From: Laura Gibbons <Laura.Gibbons@arun.gov.uk>
Sent: 14 October 2019 10:20
To: Planning.Responses <Planning.Responses@arun.gov.uk>
Cc: Amber Willard <Amber.Willard@arun.gov.uk>
Subject: RE: Planning Consultation on: AL/83/19/DOC

Engineers Comments Regarding Surface Water Drainage

Registered: 2nd October
2019
Site Address: Little Glebe Littleheath Road Aldingbourne BN18 0SR
Grid Reference: 494545 107392
Description of Works: Approval of details reserved by condition imposed under Ref
AL/111/18/HH relating to Condition No 3 - surface water drainage.

Project:	Little Glebe	Date:	Mar 2019	Made by:	KS	Sheet No.	1
CALCULATION SHEET		Job No.	1904	Chkd:	-	Rev.	A

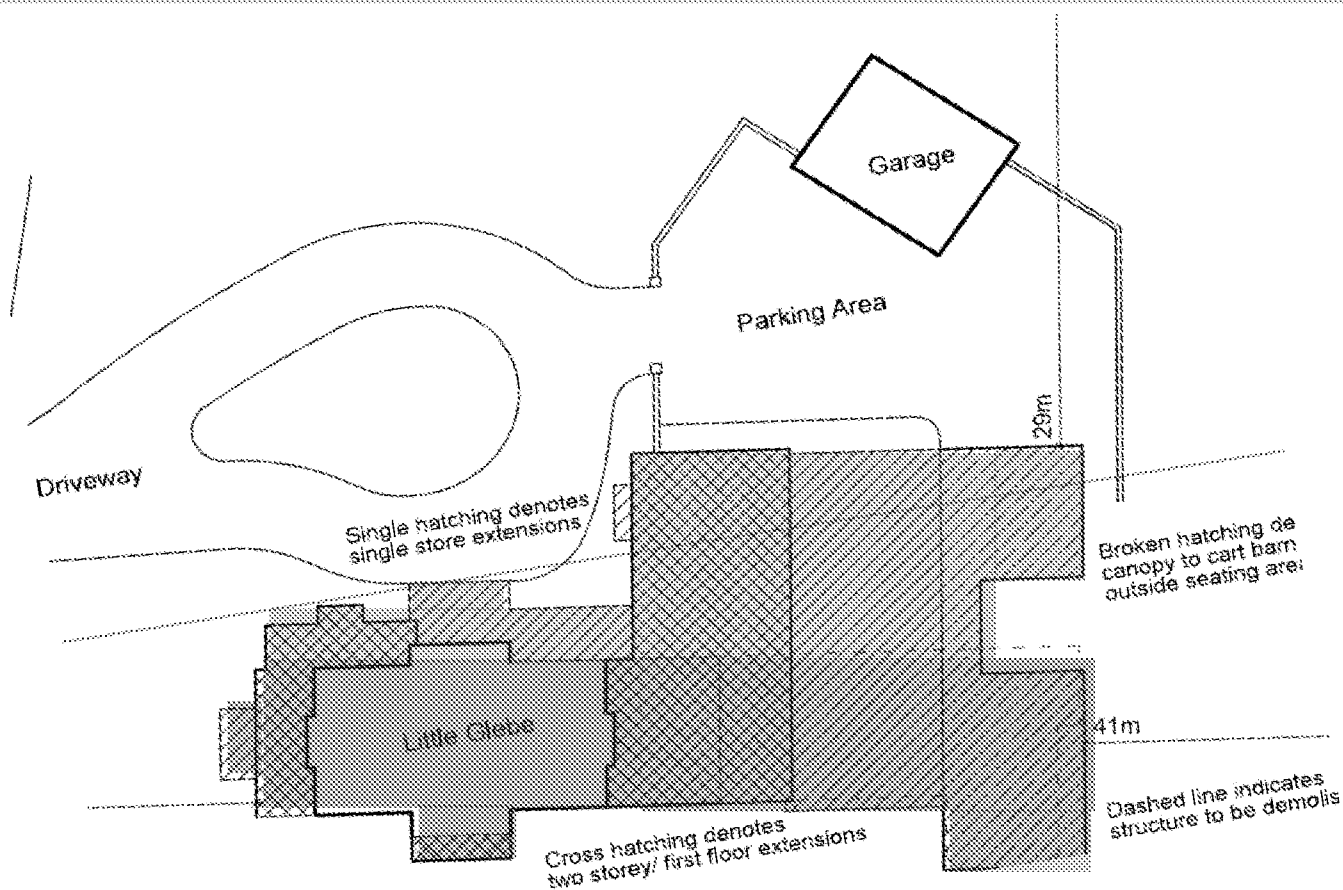
1. The drainage layout provides two proposed sites for soakaways, yet only one infiltration test has been completed and this not in accordance with BRE 365. The infiltration test was completed to a depth greater than that of the soakaway(s) proposed. The test was completed once rather than filled three times. No location for this test has been provided.
2. No formal winter ground monitoring was completed.
3. The drainage layout has no invert or cover levels.
4. The base of the bottom of the soakaway crates described on the drainage layout indicate that the depth will be greater than that described on the proposal checklist.

1. Winter groundwater monitoring and infiltration testing are completed in accordance with BRE 365 at the proposed soakaway locations and depths. The results of which are used to inform the amended design, submitted with appropriate calculations, invert and cover levels. Or,
2. A higher factor of safety (3) is used to compensate for inadequate testing, thus upsizing the soakaway(s). The updated calculations are submitted alongside invert and cover levels on the new drainage layout.
